30 September 2016  
Our Ref: 26522 KAB  
Your Ref: DA485-12-2002

**REQUEST TO MODIFY A DEVELOPMENT APPROVAL UNDER SECTION 75W OF THE EP&A ACT –  
DEVELOPMENT APPLICATION 485-12-2002 FOR A RESIDENTIAL SUBDIVISION – NADINE STREET,  
SANCTUARY POINT.**

TYPICAL 5m ROAD 01 CROSS SECTION
SCALE 1:50

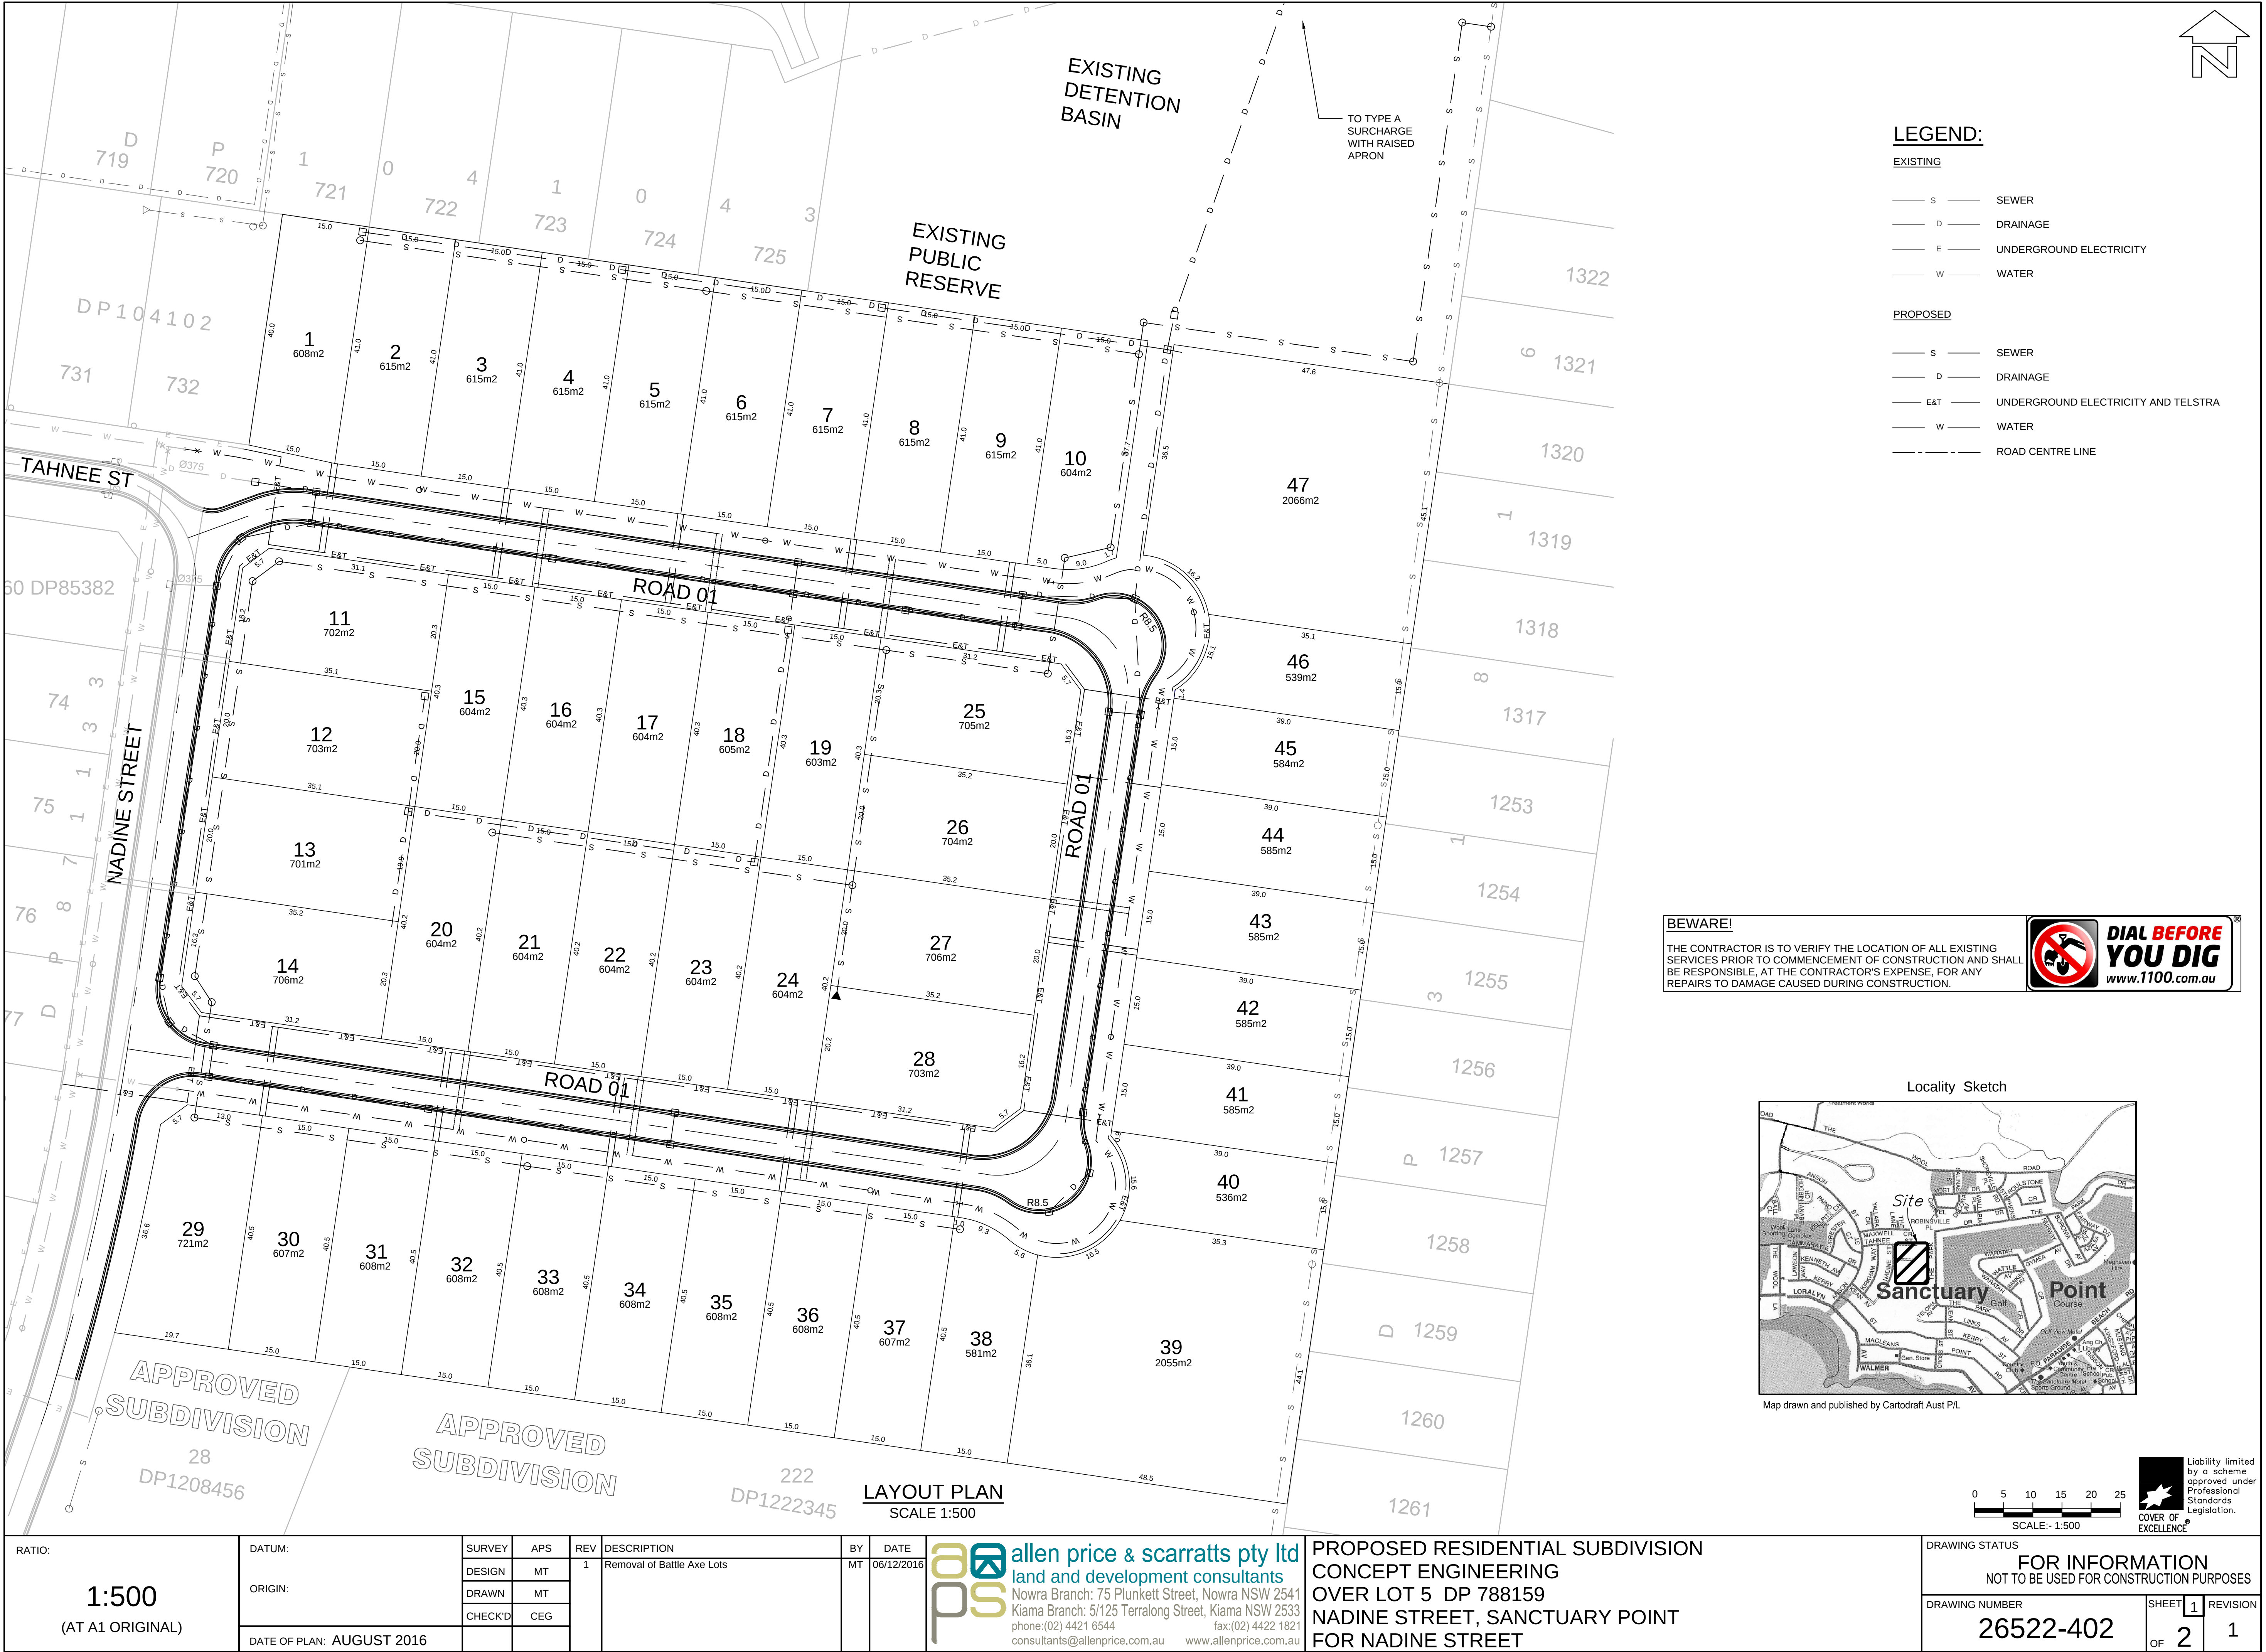
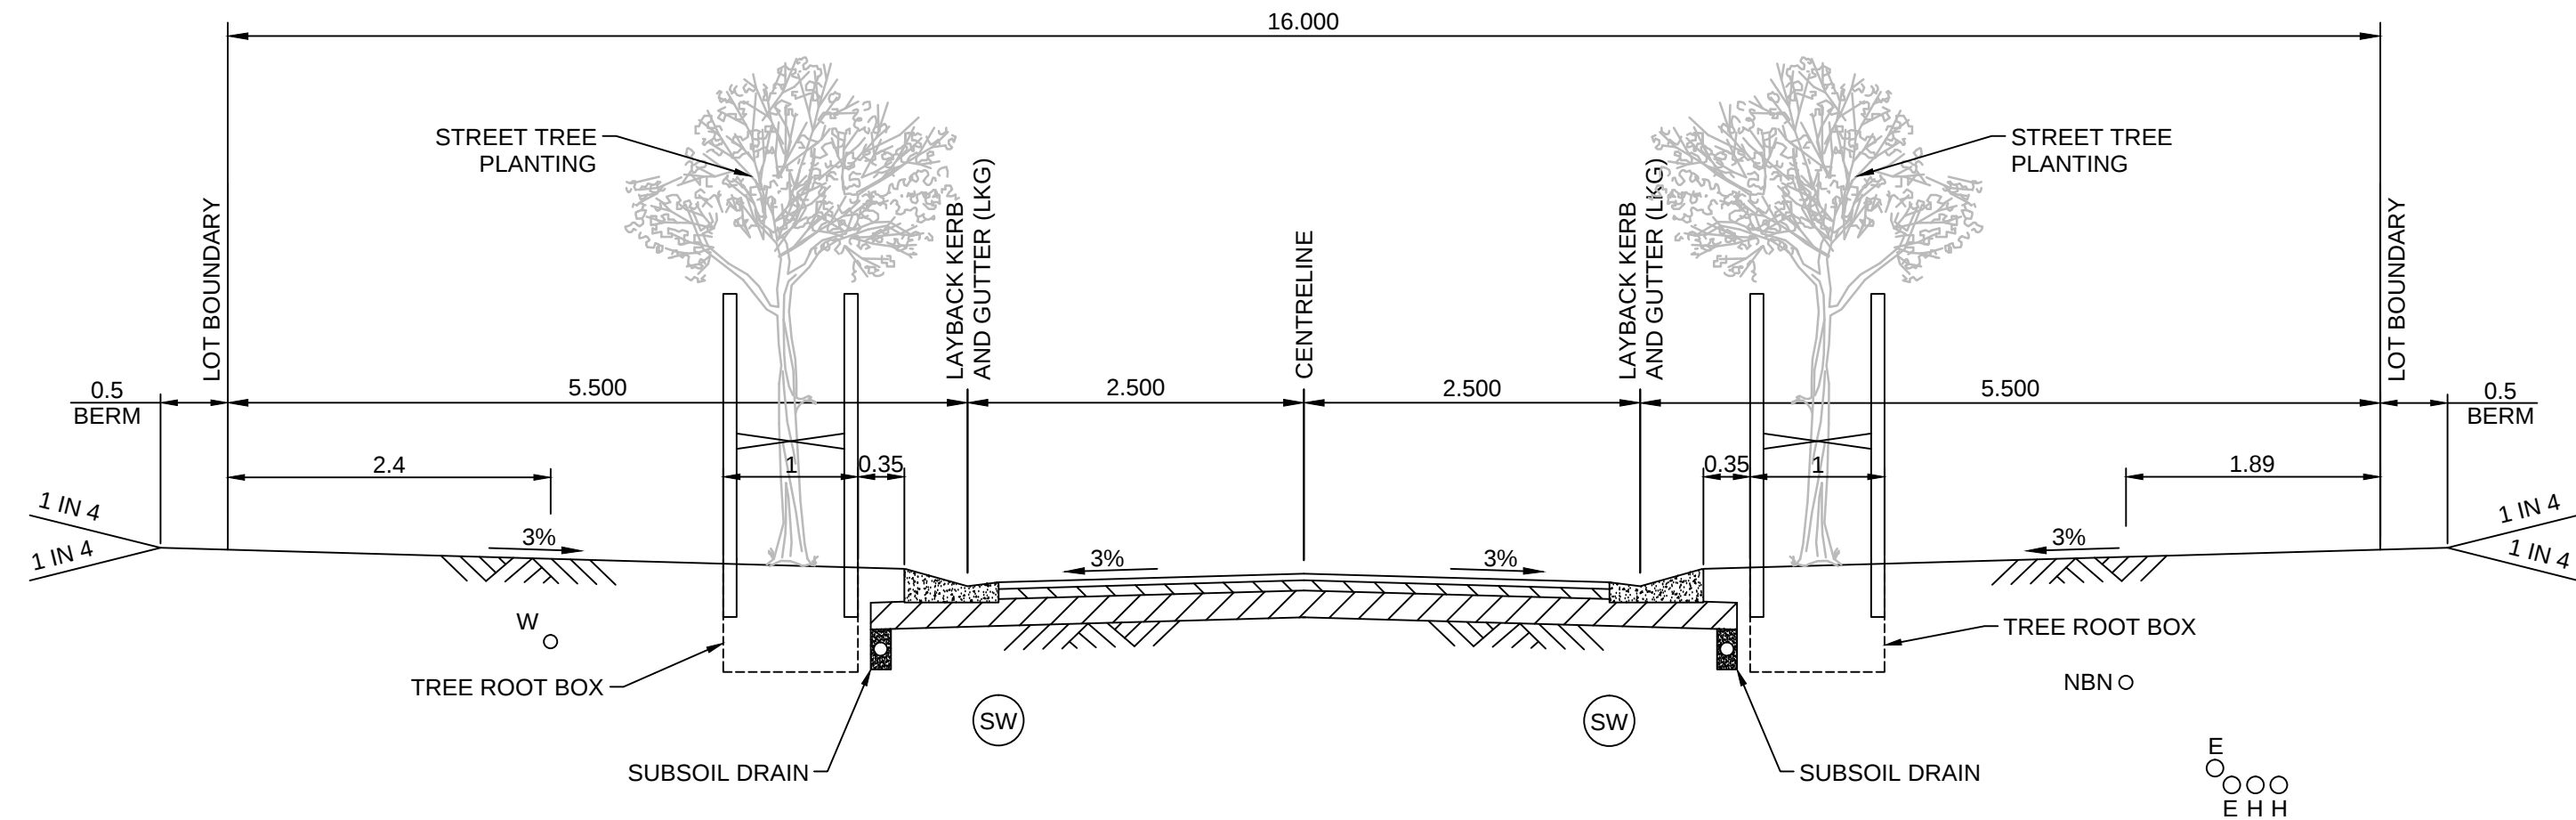
- (a) **The residential streets are to each have a carriageway of 5 metres. The pavement is to be designed for a traffic loading of 6 x10<sup>4</sup> ESA and to be surfaced with a layer of asphalt. The pavement thickness is to be determined from the charts in APRG Report No. 21. The pavement is to be contained with layback kerb and gutter. Subsoil drainage is to be provided behind the kerb line.**

**Reason:** There is no DCP requirement or engineering standard requiring the road pavement material to be concrete. It is proposed that the road construction material will be flexible pavement and no section of the road will be constructed of concrete.

REV	DESCRIPTION	BY	DATE	RATIO: 1:1000 (AT A3 ORIGINAL)		DATE OF PLAN: 06.09.2016
				DRAWING NUMBER 26522-03	SHEET 1 OF 1	REVISION P0

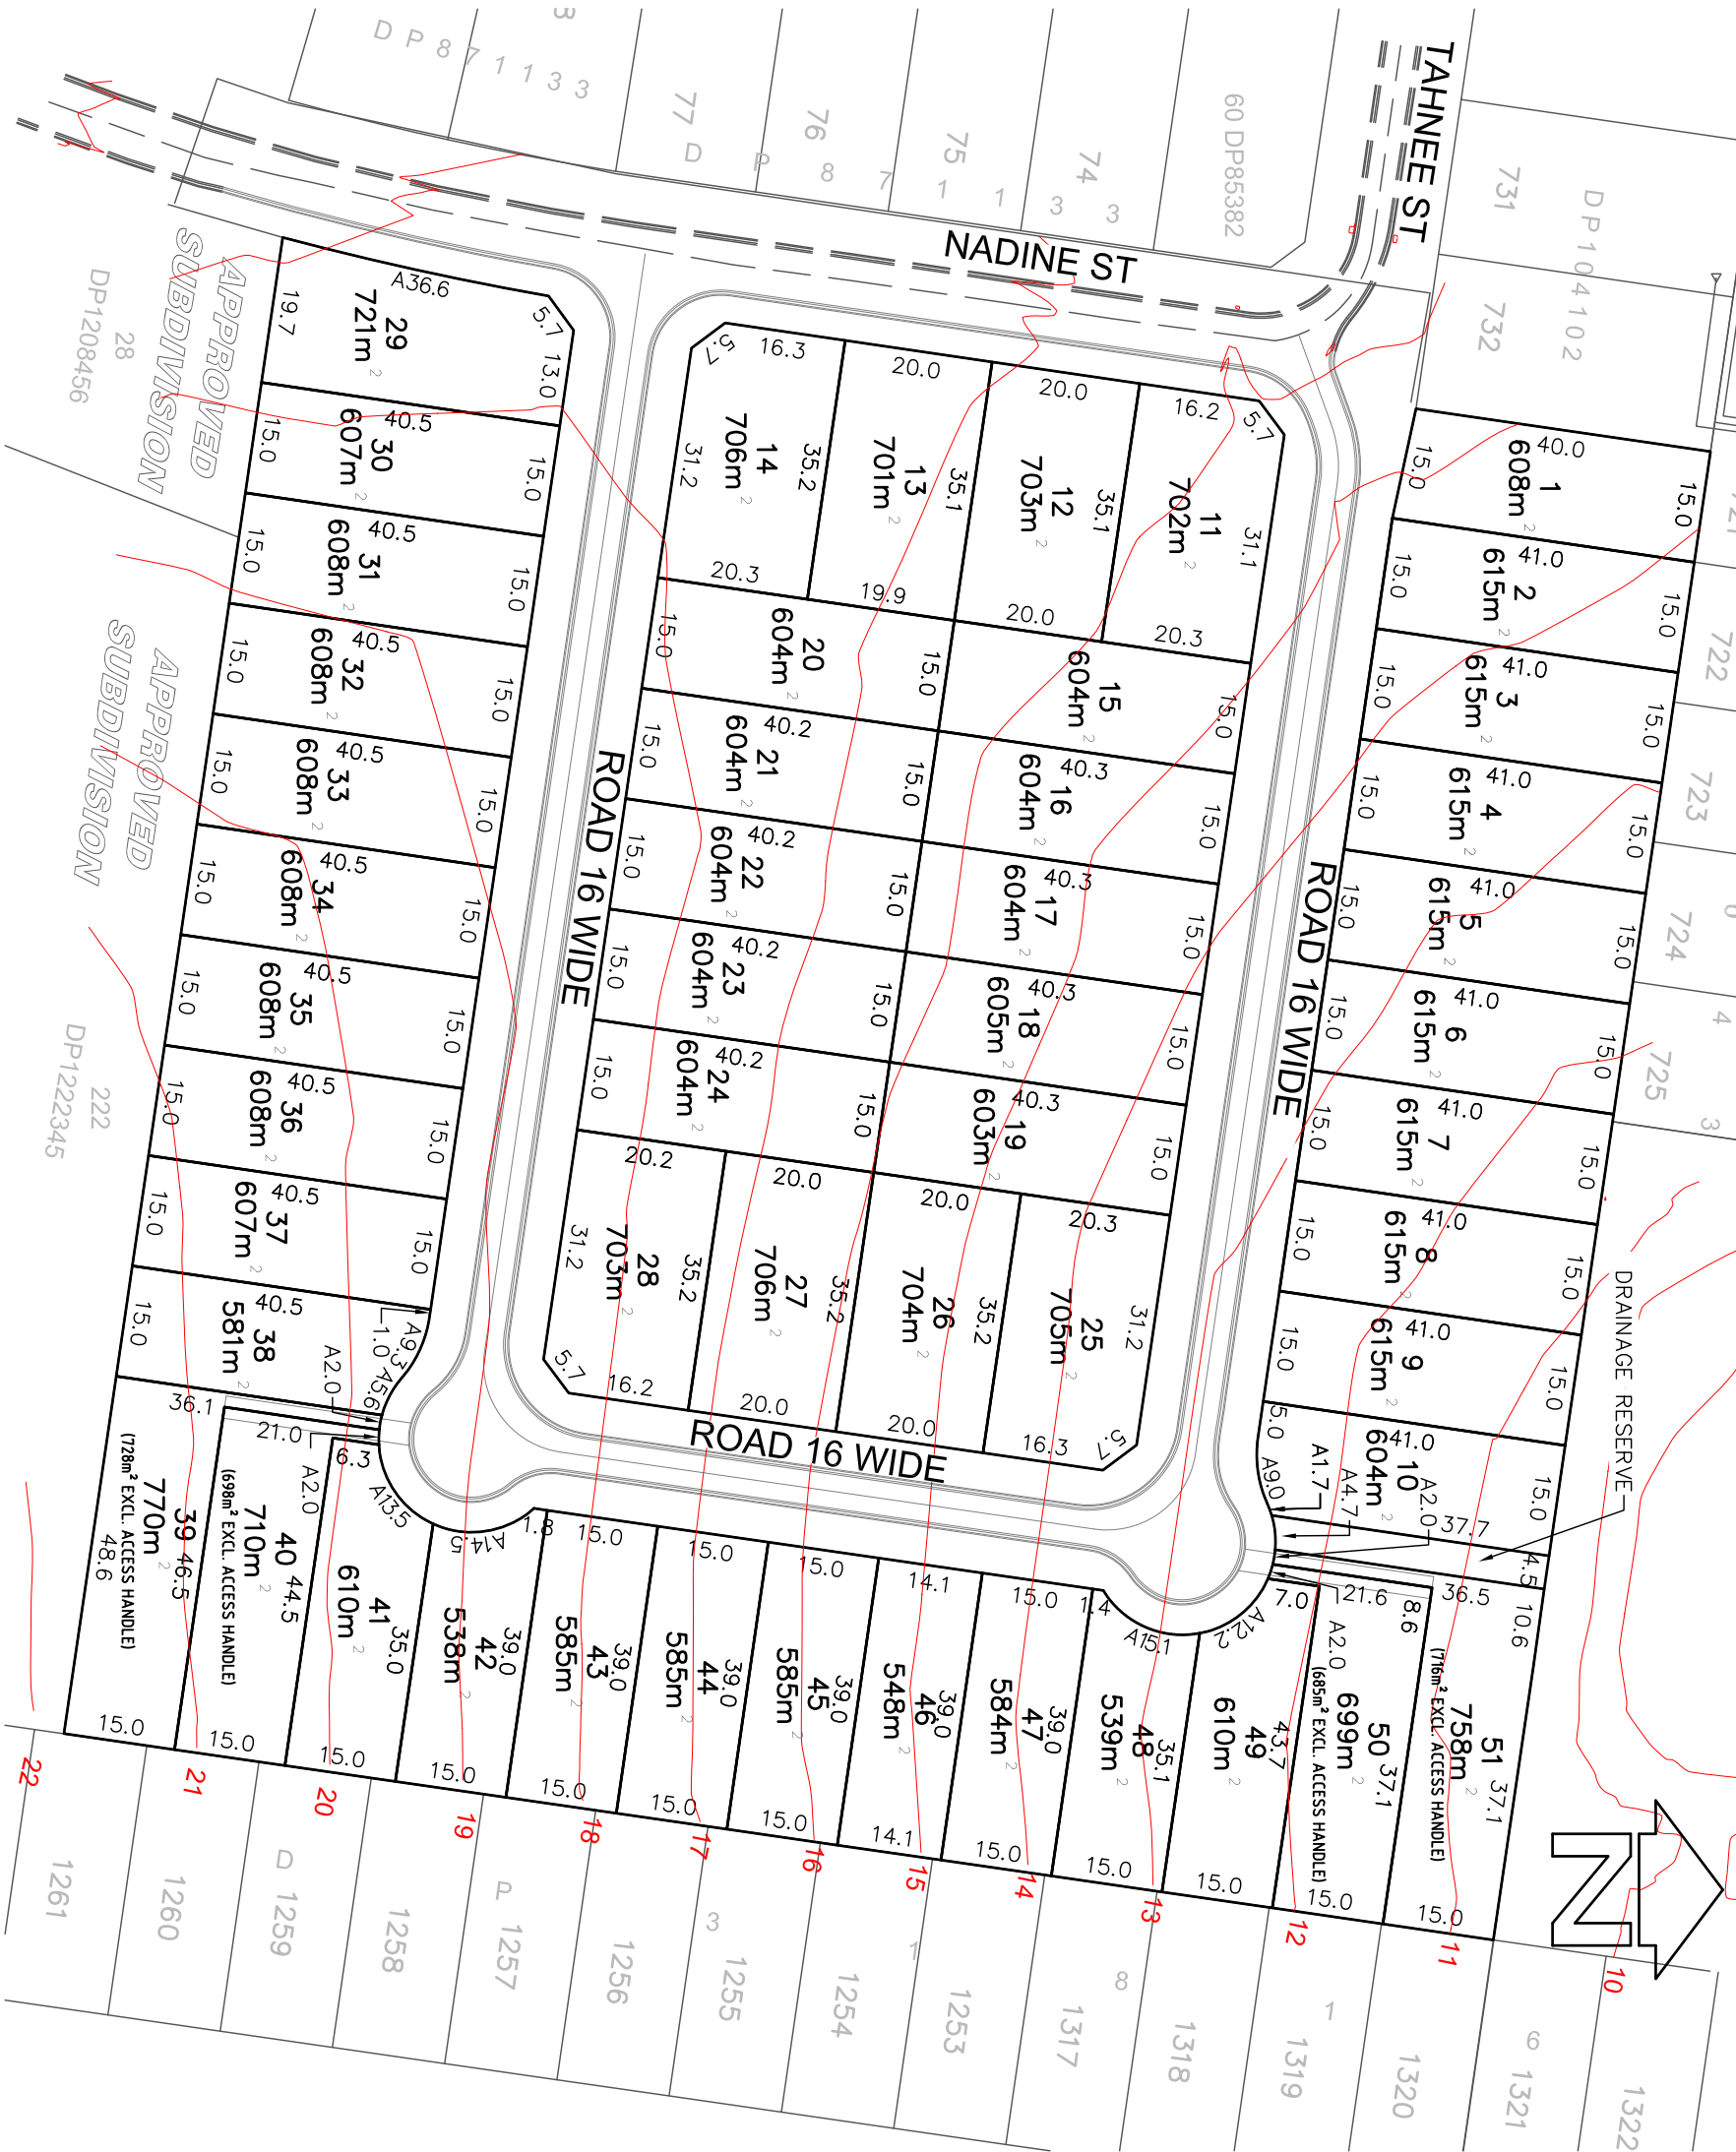
**Reason:** The plan referred to in development application **485-12-2002** was approved on 3 August 2005. The attached plan number 26522-03; Revision PO; titled Plan of Proposed Residential Subdivision; dated 6 September 2016, supersedes the previous approved plan as a result of the modifications to the allotment layout and numbers and drainage configuration.

- **Deletion of the detention basin** - Stormwater detention is proposed to take the form of oversized rainwater/detention tanks for individual dwellings and therefore a Council-owned end-of-line detention basin is not a requirement to protect the local drainage network from increases in peak runoff flow rates. In accordance Chapter G2 of the Shoalhaven (DCP), titled Sustainable Stormwater Management and Erosion/Sediment Control, acceptable solution A4.7 states *‘For subdivisions it is recommended that OSD is at the individual dwelling scale. Where OSD is proposed on public land, the OSD system must be kept to a minimum’*. Therefore the proposed stormwater detention is consistent with the requirements of the DCP.

- **Reconfiguration of the proposed lot layout and increasing the number of lots from 39 to 51** – The site lot layout is proposed to be altered primarily as a result of the deletion of the detention basin and the alteration of the lot widths.

- **Modification of the road design and cul-de-sac heads** – The proposed development seeks approval for minor alterations to the road design and cul-de-sac in order to provide a more efficient flow of traffic within the development. The modified road layout will also improve circulation for fire tankers.

**Reason:** The plan referred to in development application **485-12-2002** was approved on 3 August 2005. The attached plan number 26522-03; Revision PO; titled Plan of Proposed Residential Subdivision; dated 6 September 2016, supersedes the previous approved plan as a result of the modifications to the allotment layout and numbers and drainage configuration.
